Ribble Valley Borough Council
Housing & Development Control

Application no: **3/2019/1034**

Address: **Teewood Farm Barns Slaidburn Road Waddington BB7 3JJ**

Proposal: **Demolition of modern agricultural buildings and conversion and extension of two barns to form one new two-storey dwelling with separate two-storey annexe building in curtilage. Closure of the existing vehicular access, construction of new access, drainage and landscaping.**

Proposed Site Plan
Scale 1:200

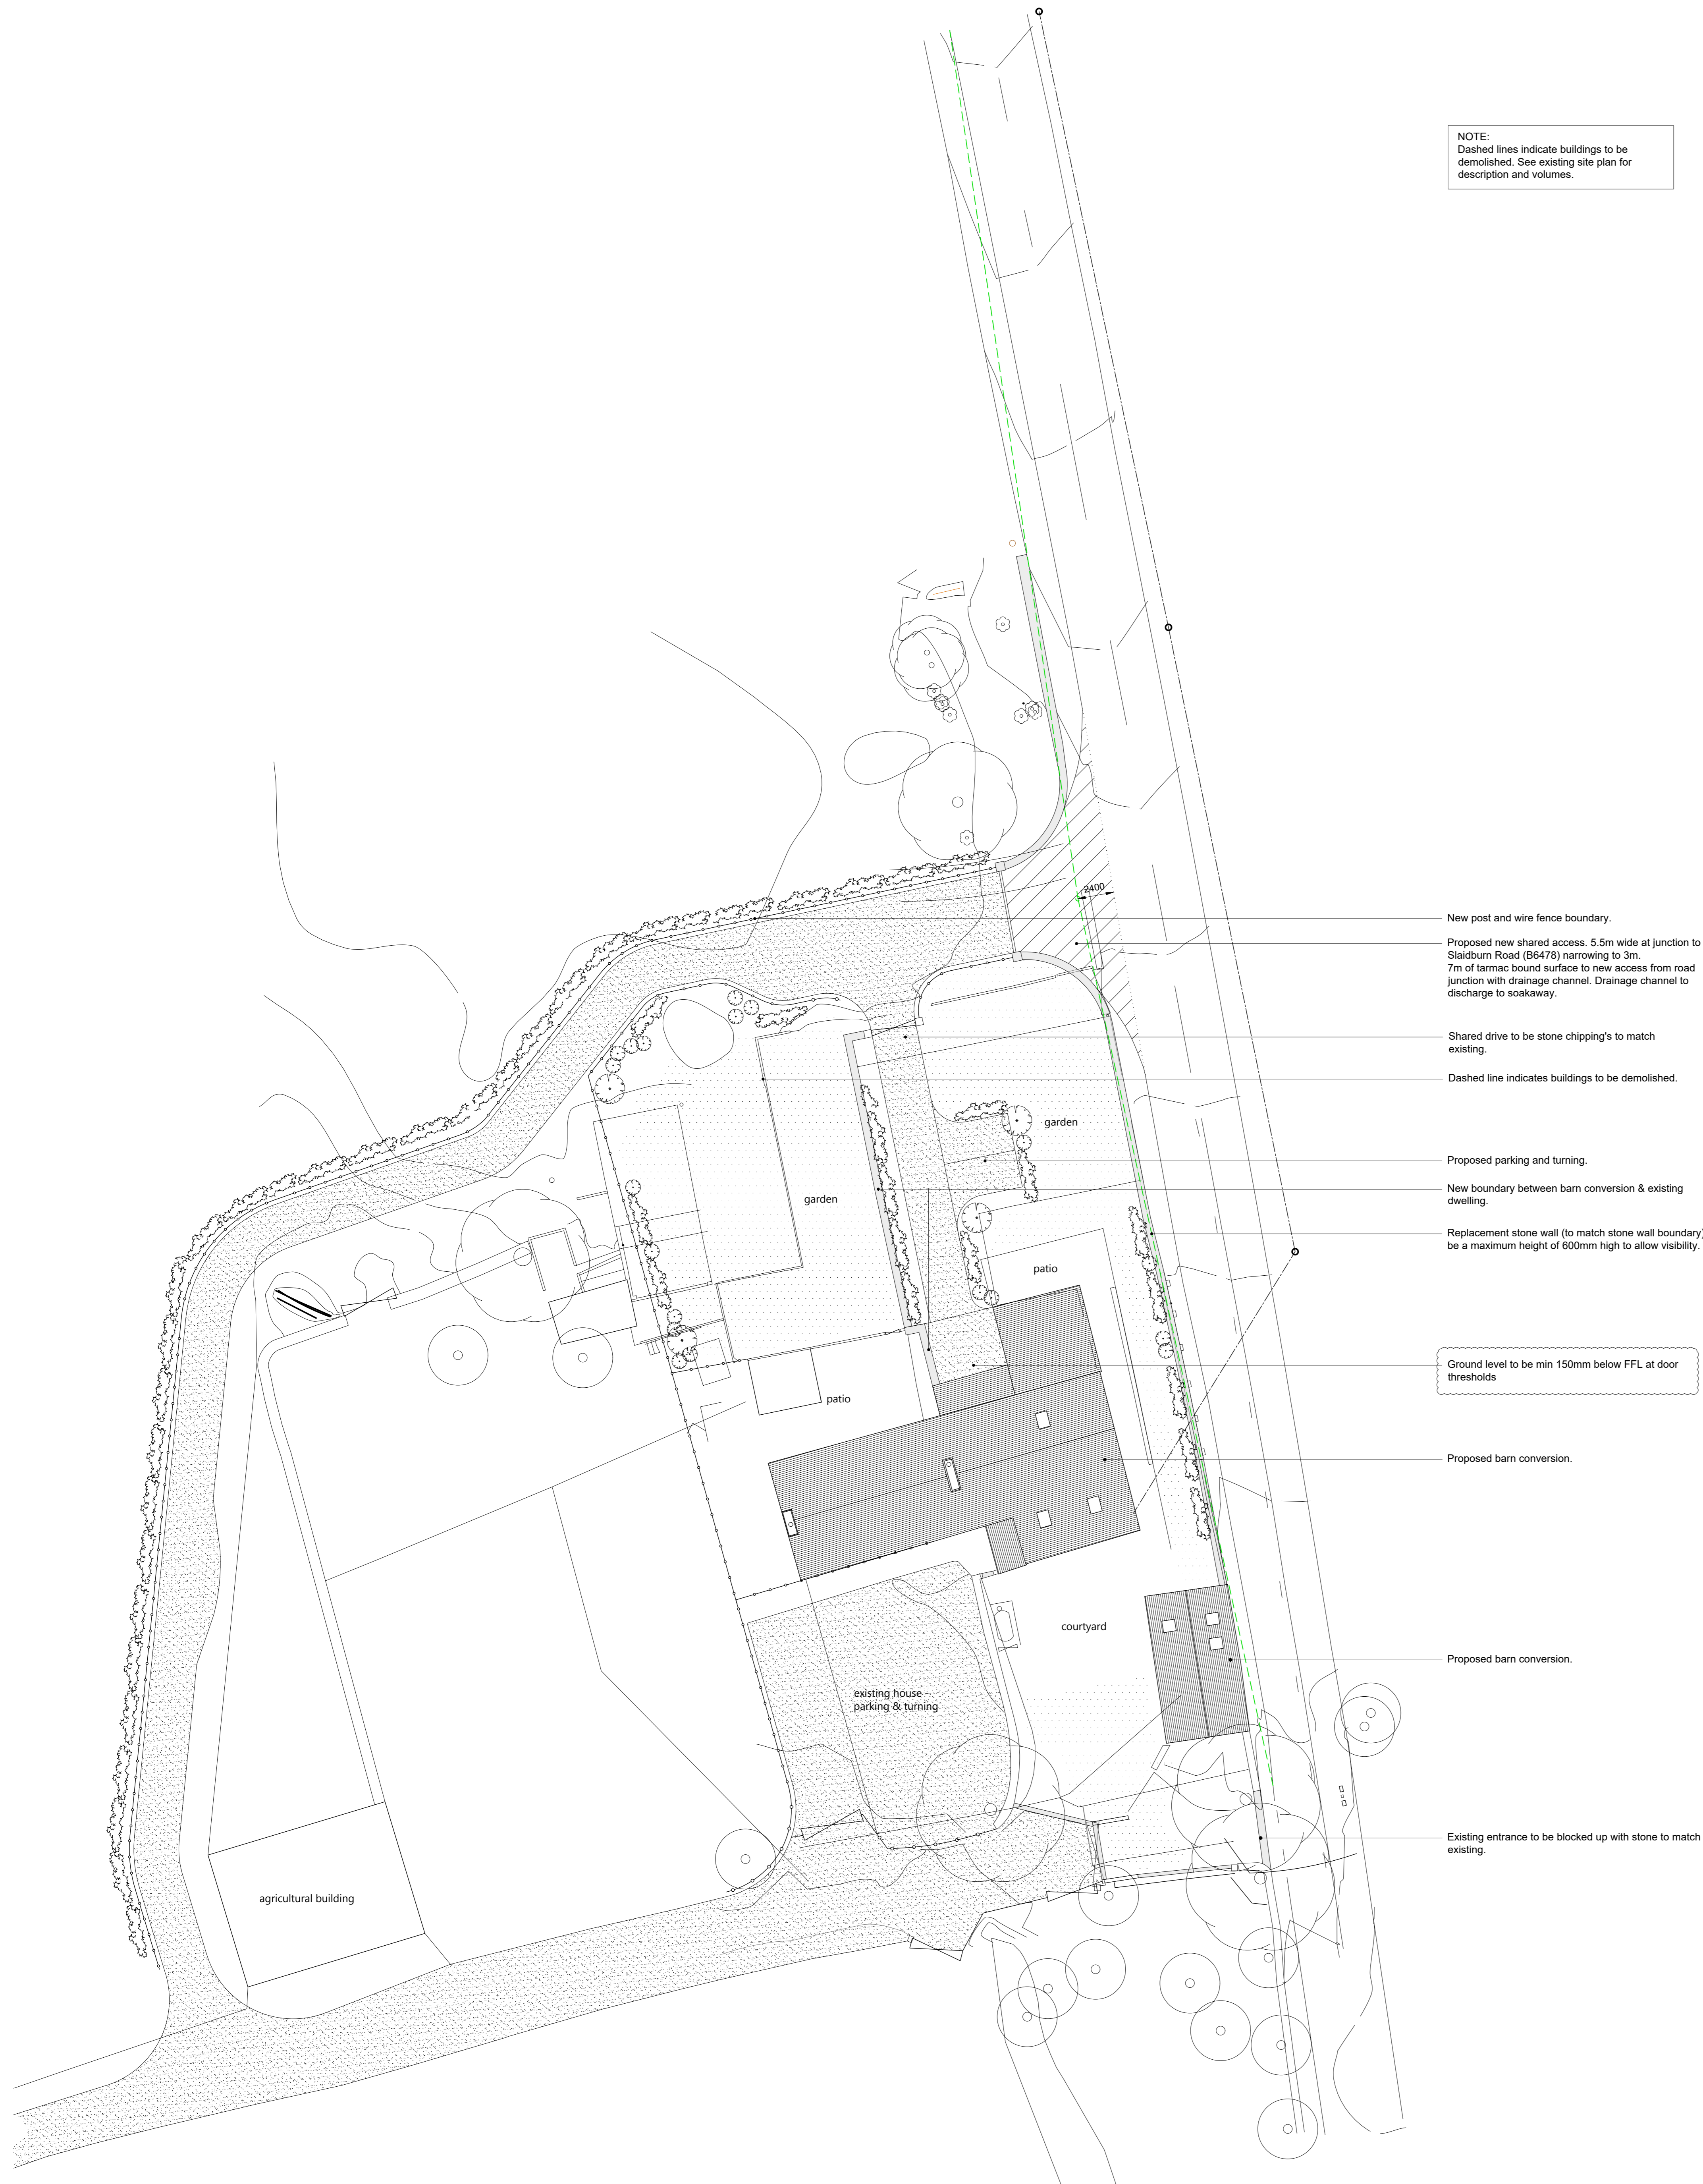
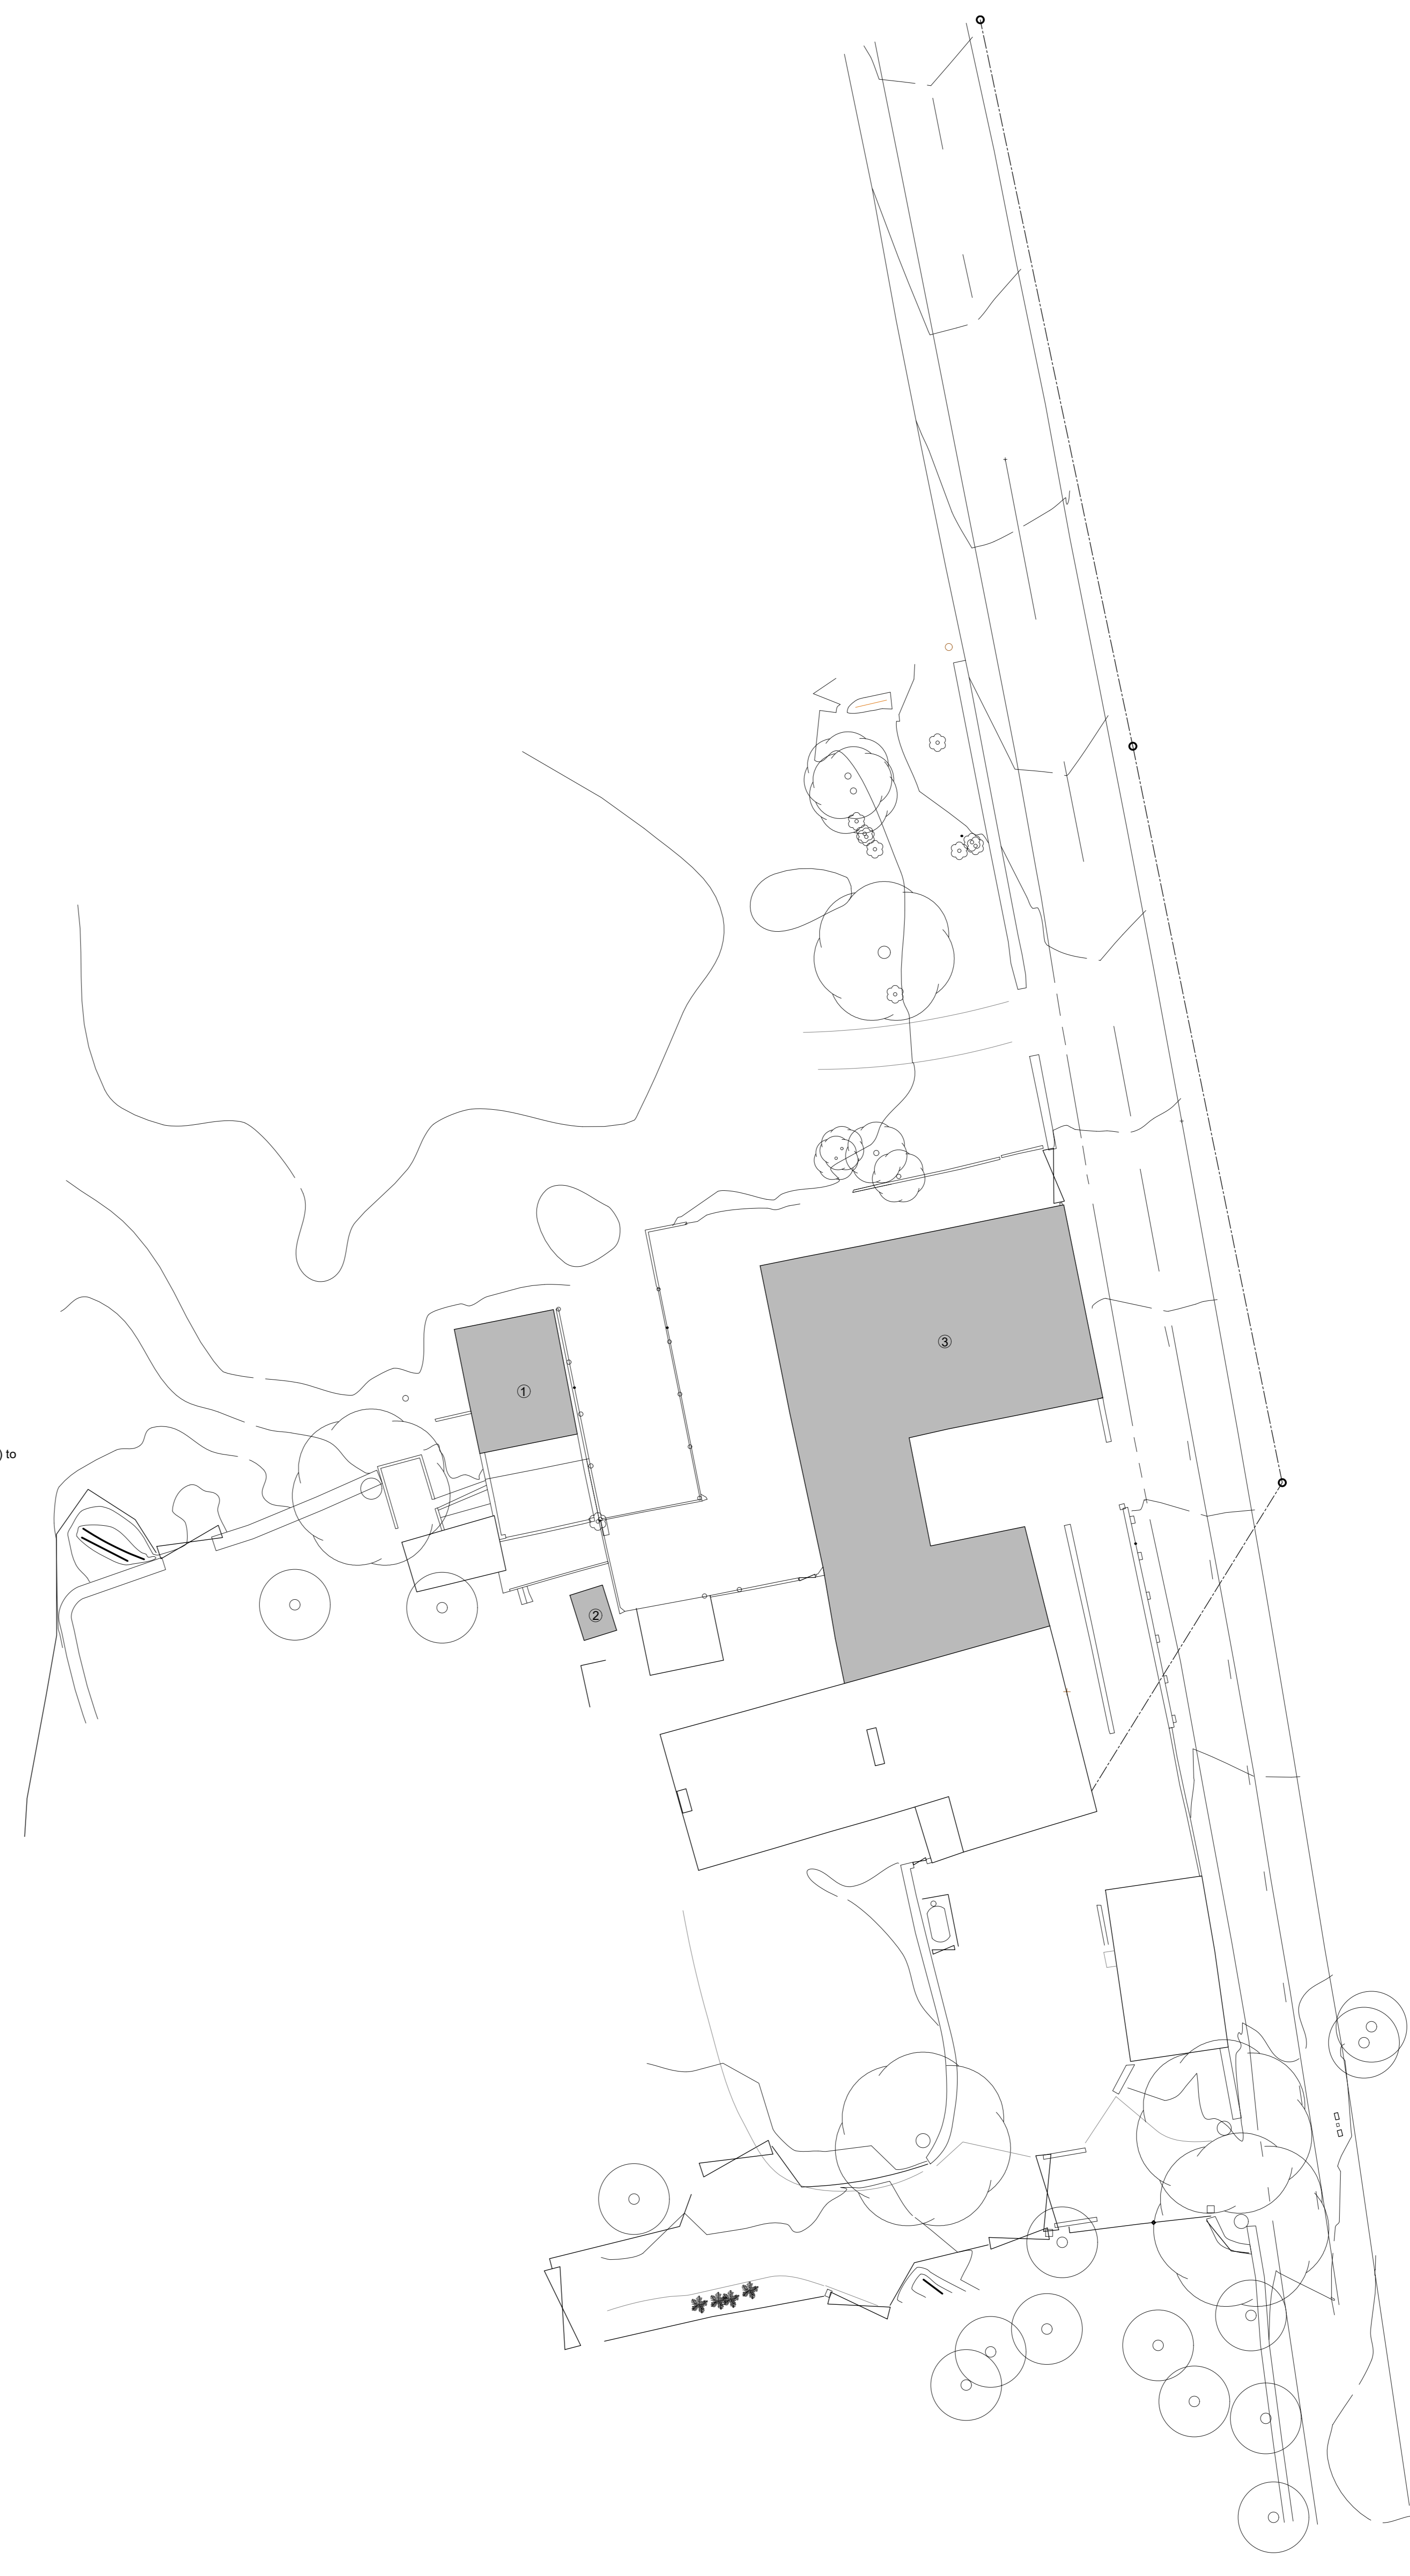
A new access point is proposed into the application site with the existing access point being stopped up and a continuation of the existing boundary wall being constructed to formalise the closure of the existing access point. The newly proposed access point meets the requirements as requested during the highways pre-planning application meeting and as previously stated the access works would need to be carried out under

The applicant proposes to replace the existing boundary wall with a 600mm stone wall to aid visibility and as such the local highway authority would request that the boundary wall and any shrubbery, vegetation or fence that may be positioned to the rear of the boundary wall is maintained at a height no greater than 1.05m in perpetuity of the development.

There is sufficient parking area proposed to support the associated parking provision and vehicles can also enter and leave the application site in forward gear whilst allowing the passing of two vehicles at the proposed access point.

3. Notwithstanding the provisions of the Town and Country Planning (General Permitted Development) Order 2015 there shall not at any time in connection with the development hereby permitted be erected or planted or allowed to remain upon the splays hereinafter defined any building, wall, fence, hedge, tree, shrub or other device over 1.05m above road level.
